Our Ref: M/62/17/HH
Your Ref:

Town & Country Planning Act 1990 (as amended)
Town & country Planning (Development Management Procedure) (England) Order 2015
Application for Planning Permission for Works or Extension to a Dwelling

Development Replace two storey rear extension & erection of rear balcony & external staircase.
Location 2 Elmer Court Middleton on Sea

West Elevation

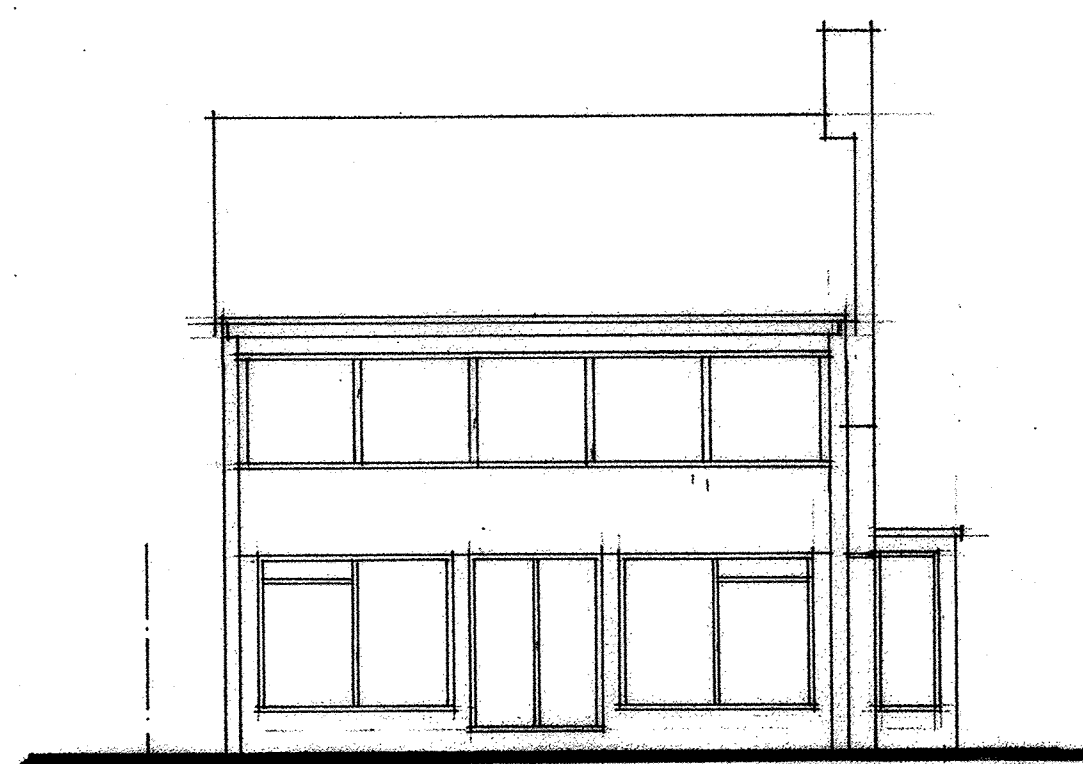
Please show the proposed staircase on the west elevation.
Flood Risk Assessment
